**DELEGATED DECISION FOR APPLICATION FOR CERTIFICATE OF
LAWFUL DEVELOPMENT**

Reference no.: 2026/CL/91365/W

Site: 22, Woodland Grove, Holmfirth, HD9 7FG

Description: Certificate of lawfulness for proposed erection of
single storey rear extension and associated alterations

Scale	Drawing Number	Rev	Date Drawn	Drawn By
1/50 & 1/100	2026/012/03		May 2026	Andrew Smith

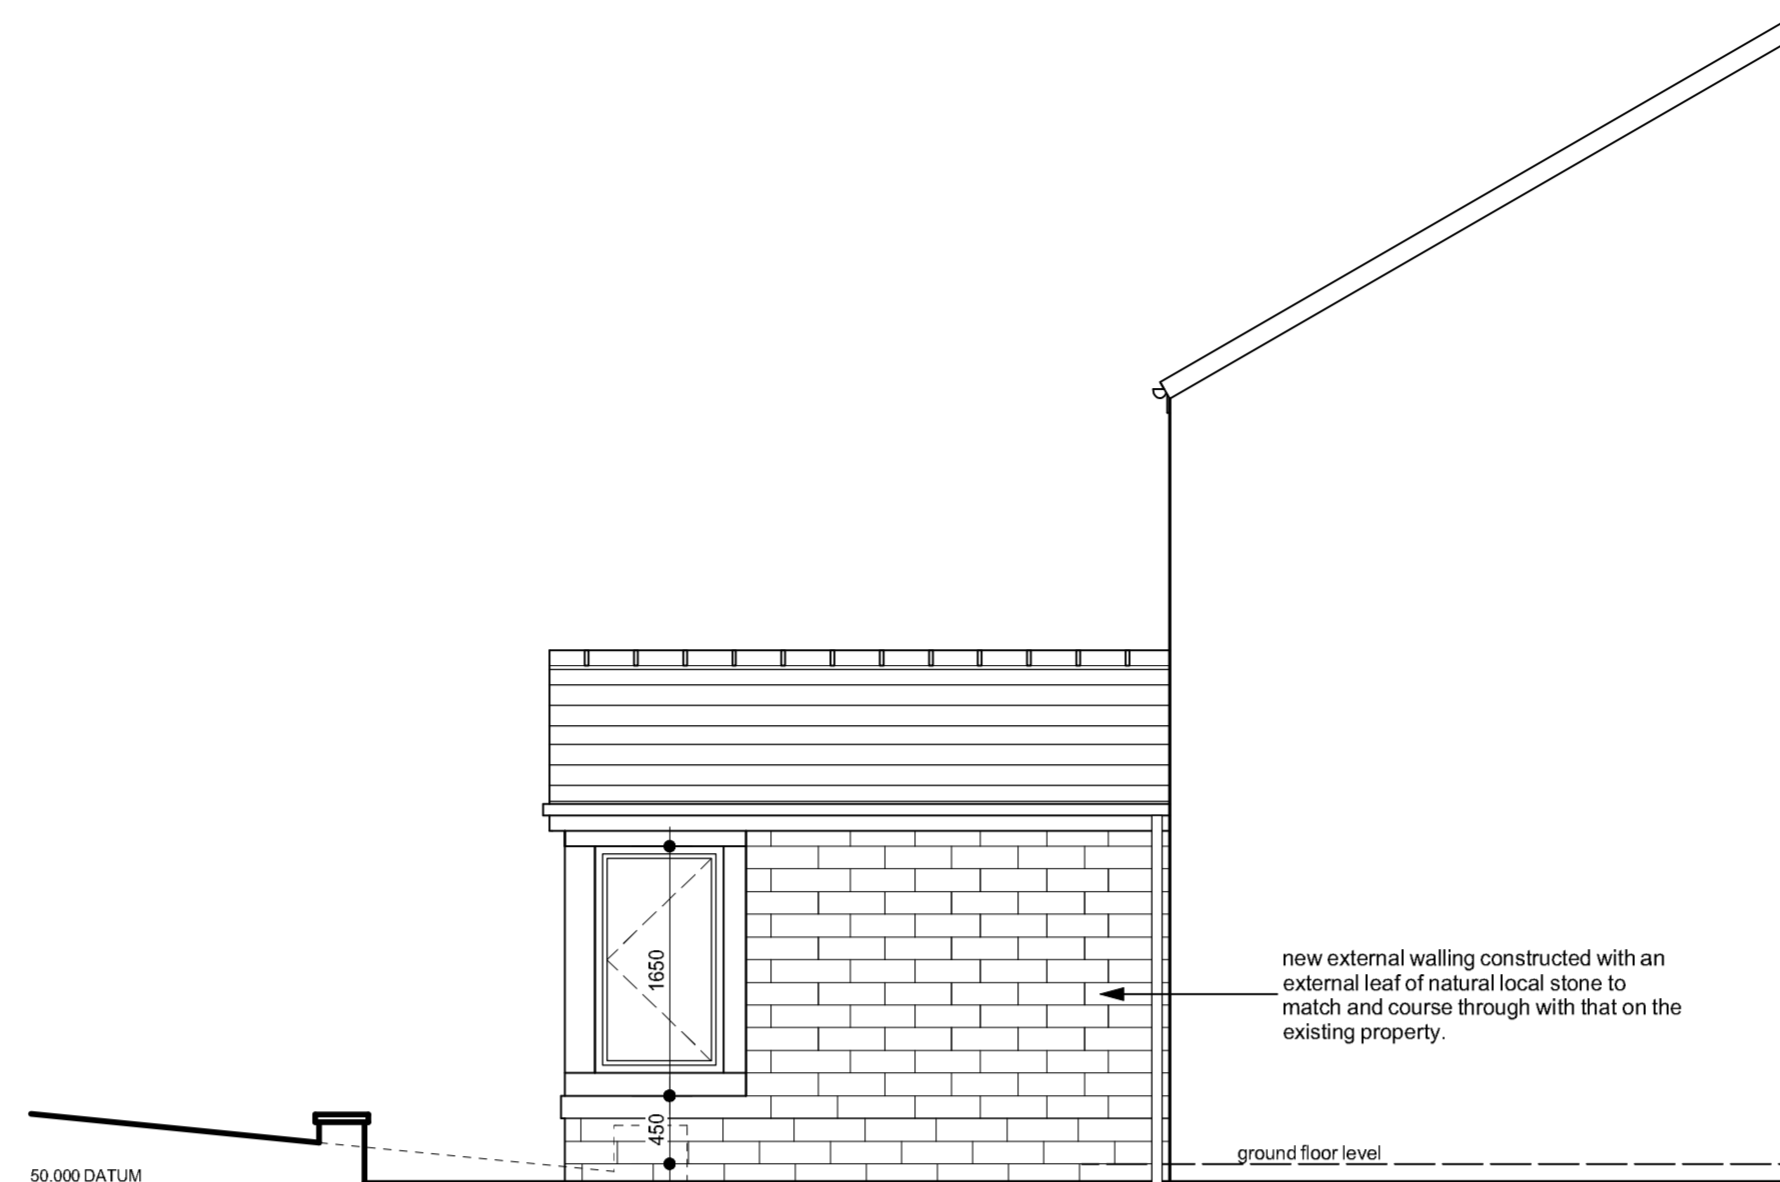
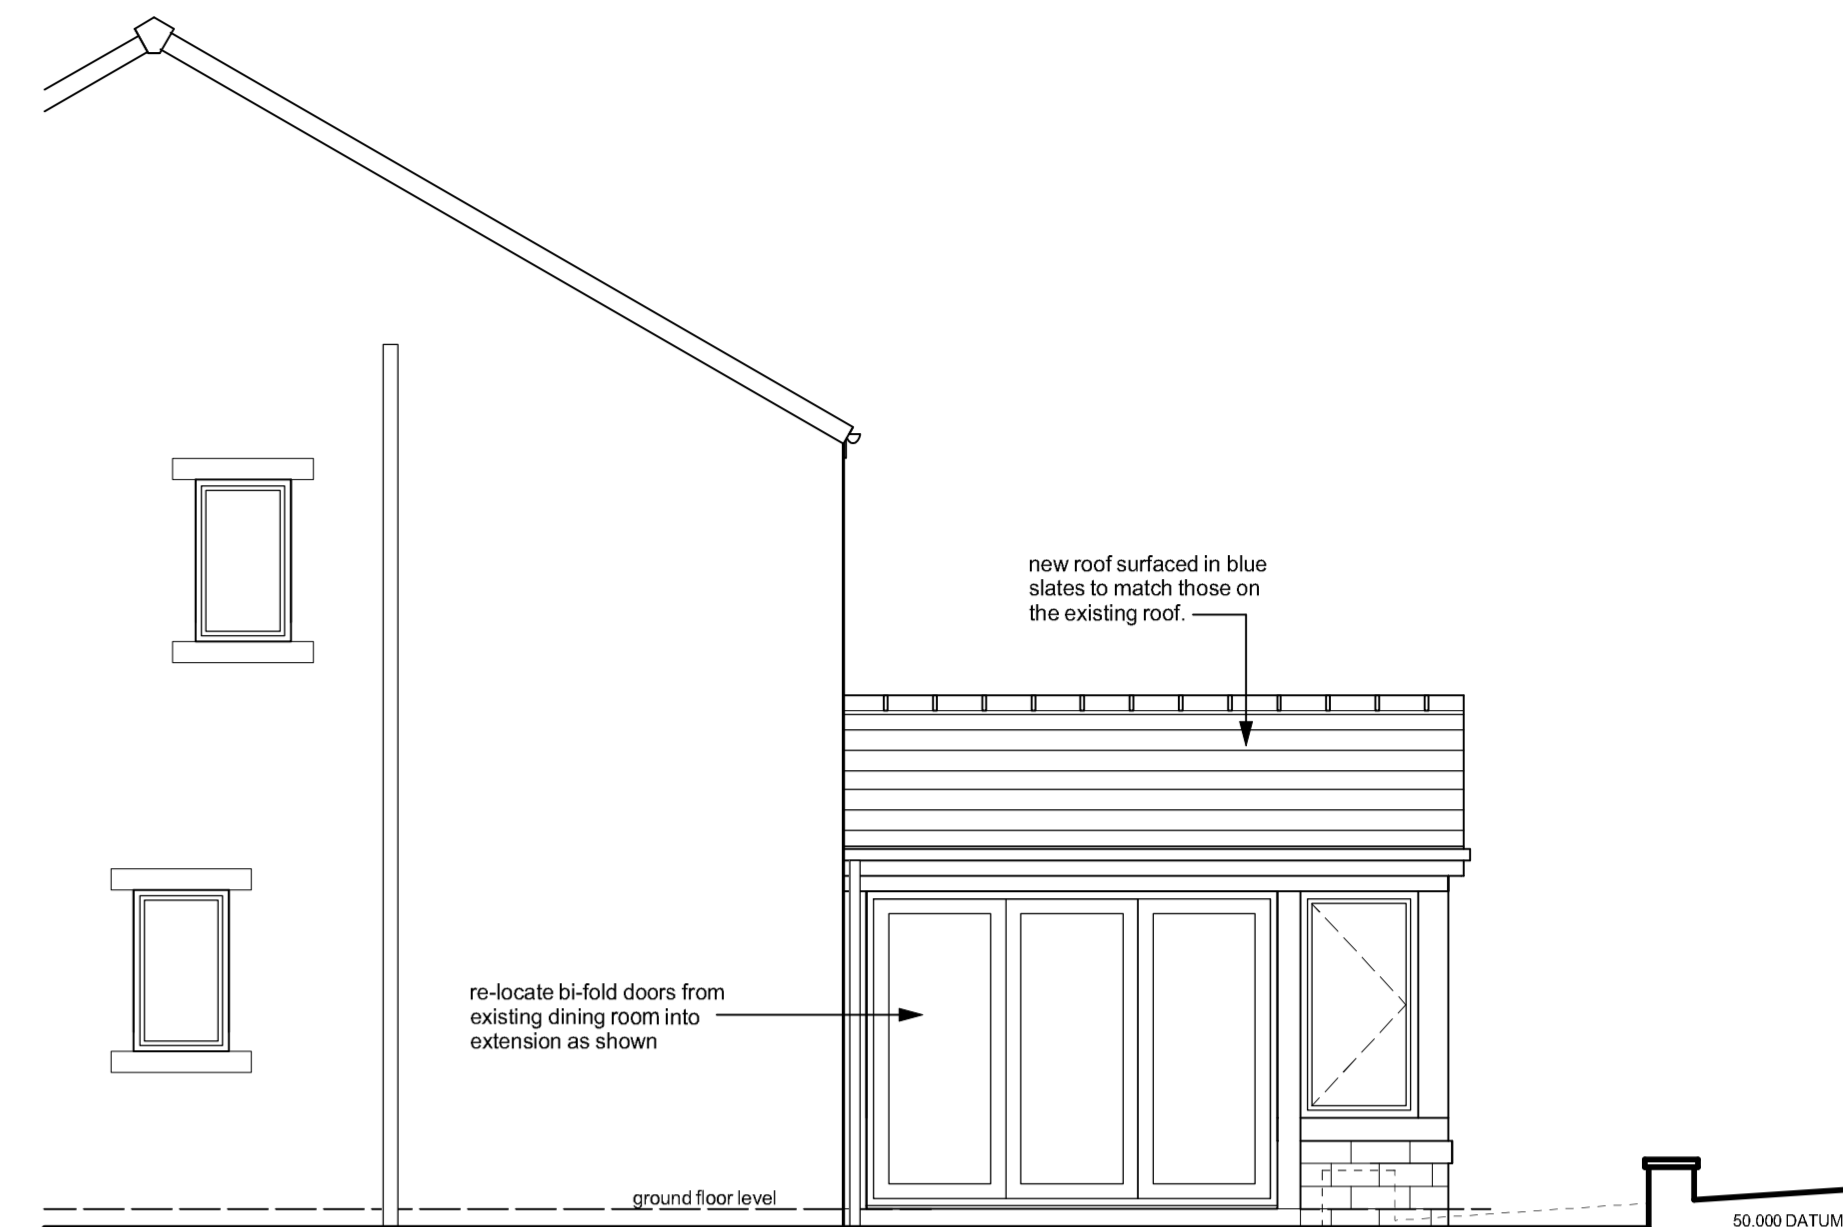
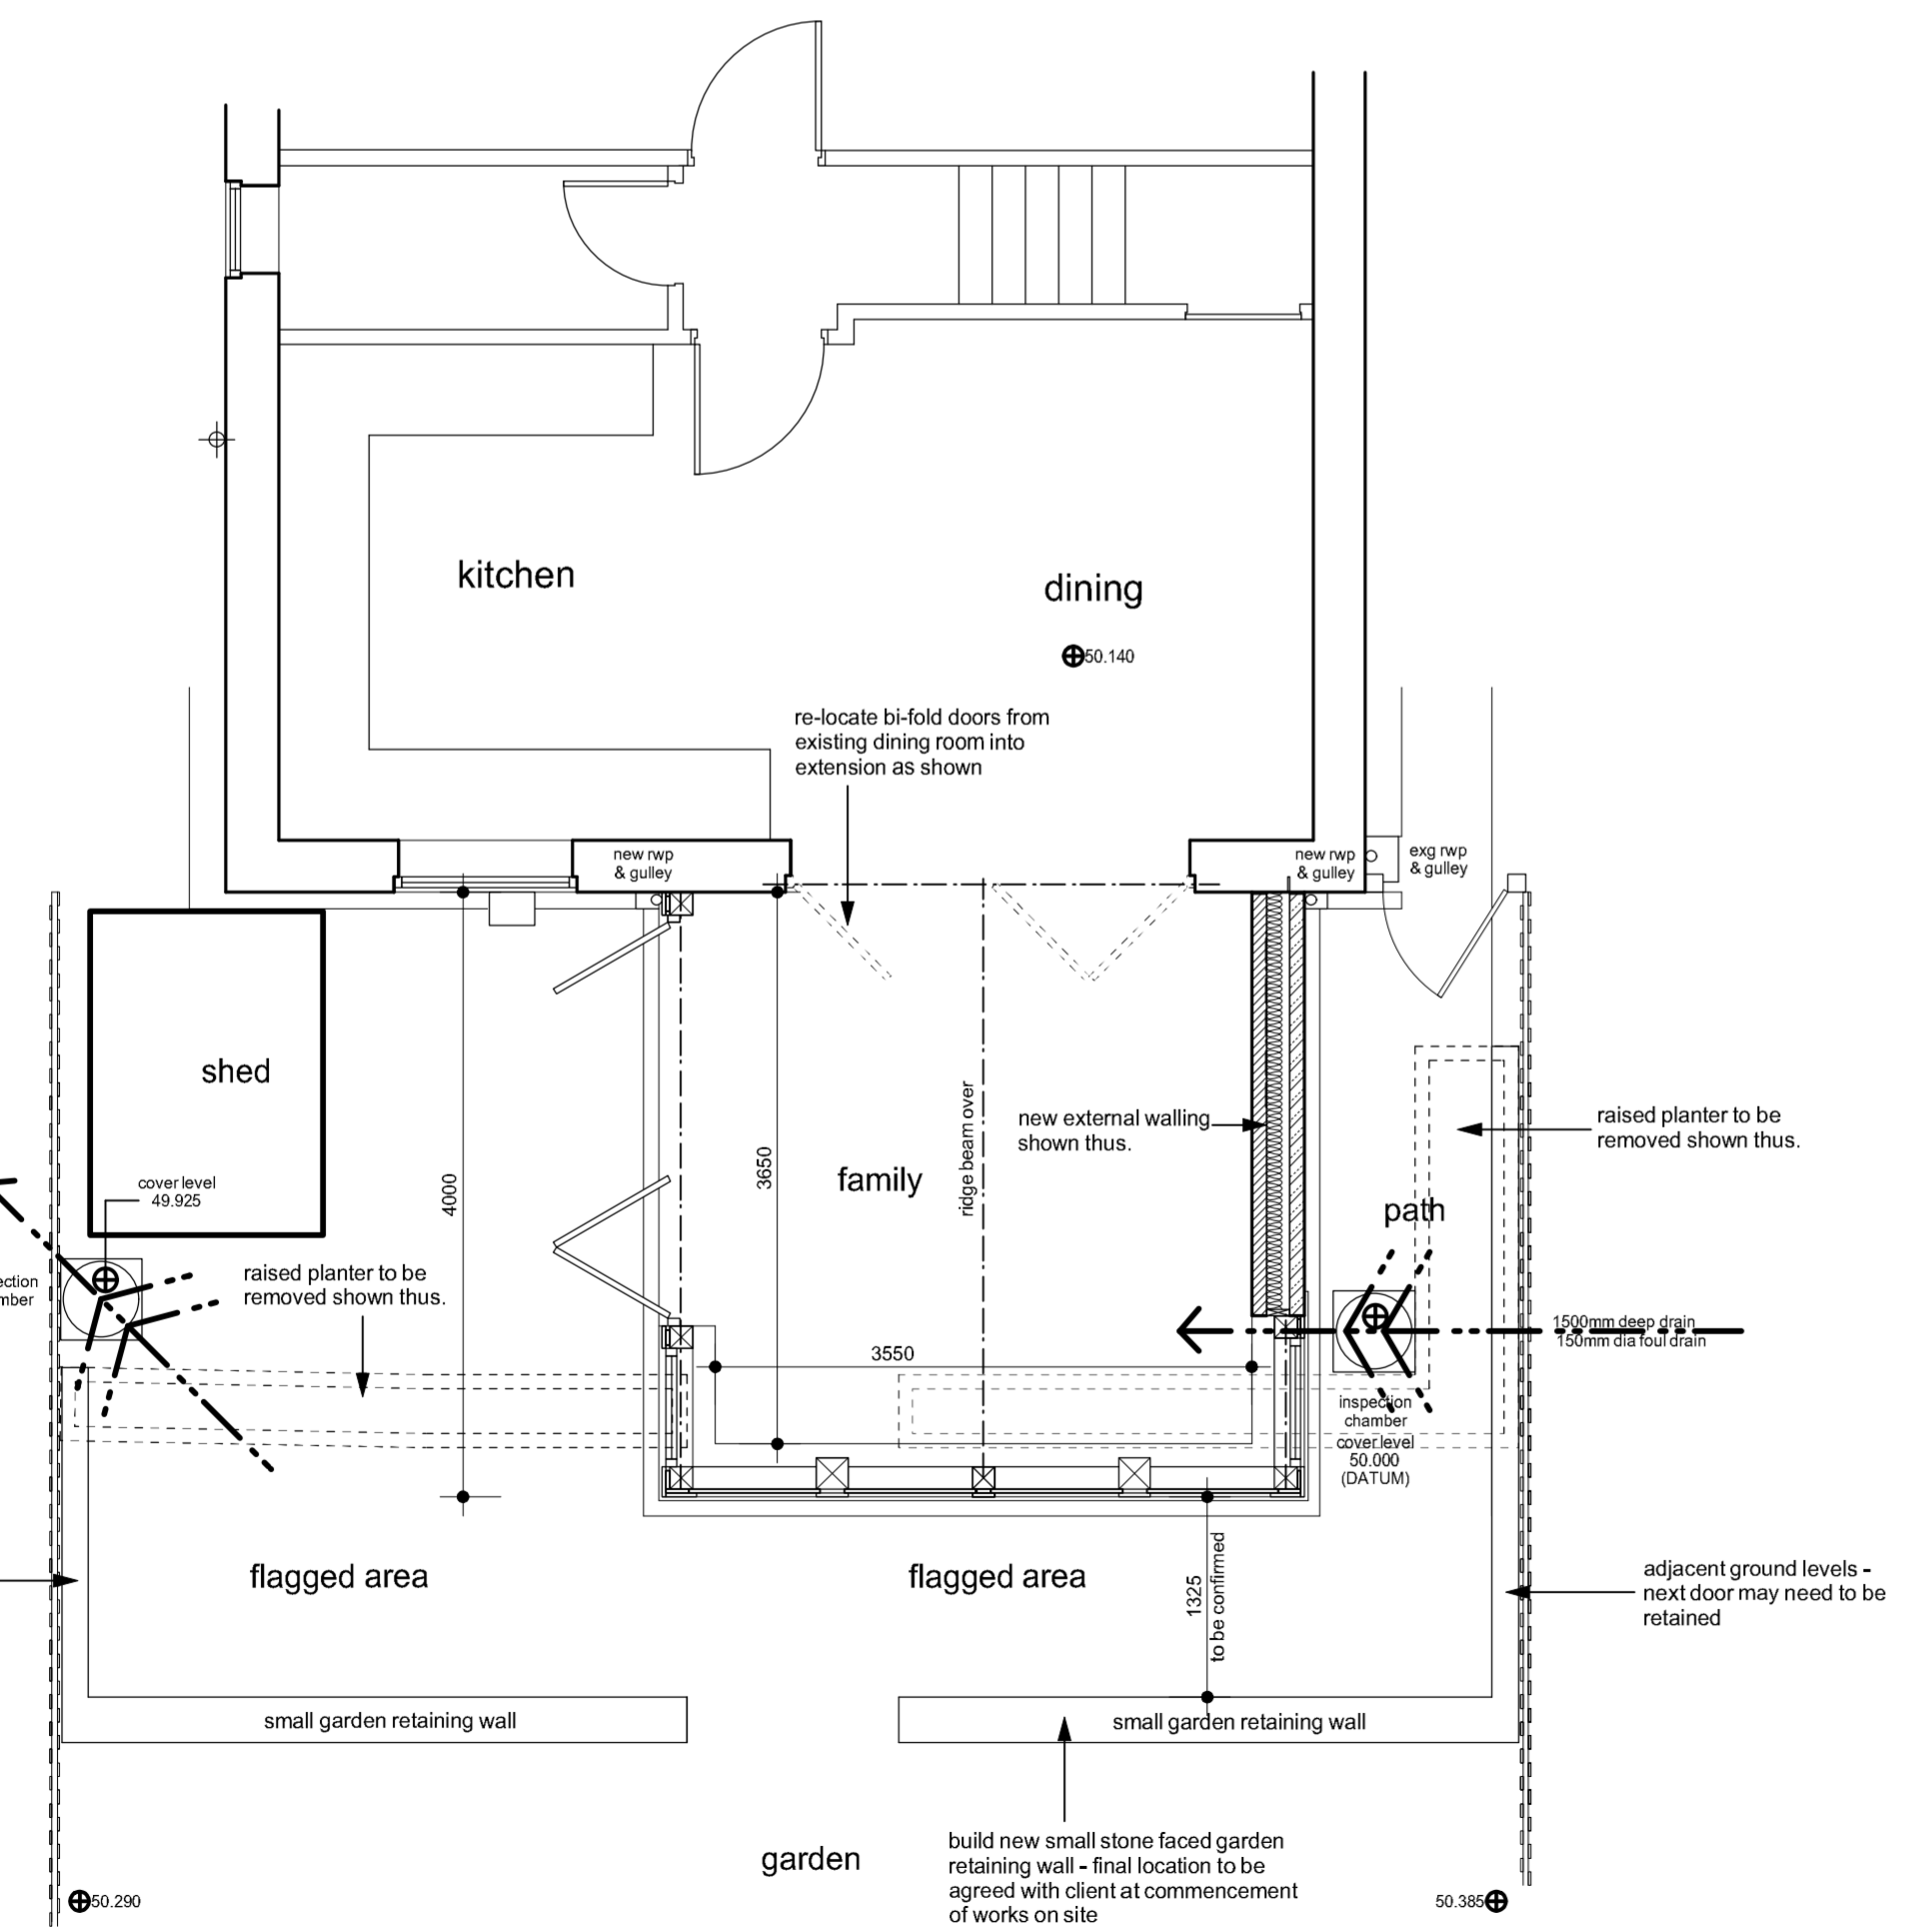
The proposed extension would be set in from both side elevations of the property and would have a width of 4.5 metres, projection from the rear door of the dwelling of 4 metres, an eaves height of 2.4 metres and overall height of 3.6 metres. The extension would be a green oak structure with the walling being natural coursed stone to match that on the existing dwelling.

Comment: *The height of the enlarged part of the building would not exceed the height of the highest part of the roof of the existing dwellinghouse.*

Comment: *The height of the eaves of the enlargement would not exceed the height of the eaves of the existing dwellinghouse.*

Comment: *The enlarged part of the dwellinghouse would have a single storey and would not extend beyond the rear wall of the original dwellinghouse by more than 4 metres and it does not exceed 4 metres on height.*

Comment: *The enlarged part of the dwellinghouse would be within 2 metres of the boundary of the curtilage of the dwellinghouse however the height of the eaves would not exceed 3 metres.*

Comment: *Not applicable as the enlarged part of the dwellinghouse would not extend beyond a wall forming a side elevation of the original dwellinghouse.*
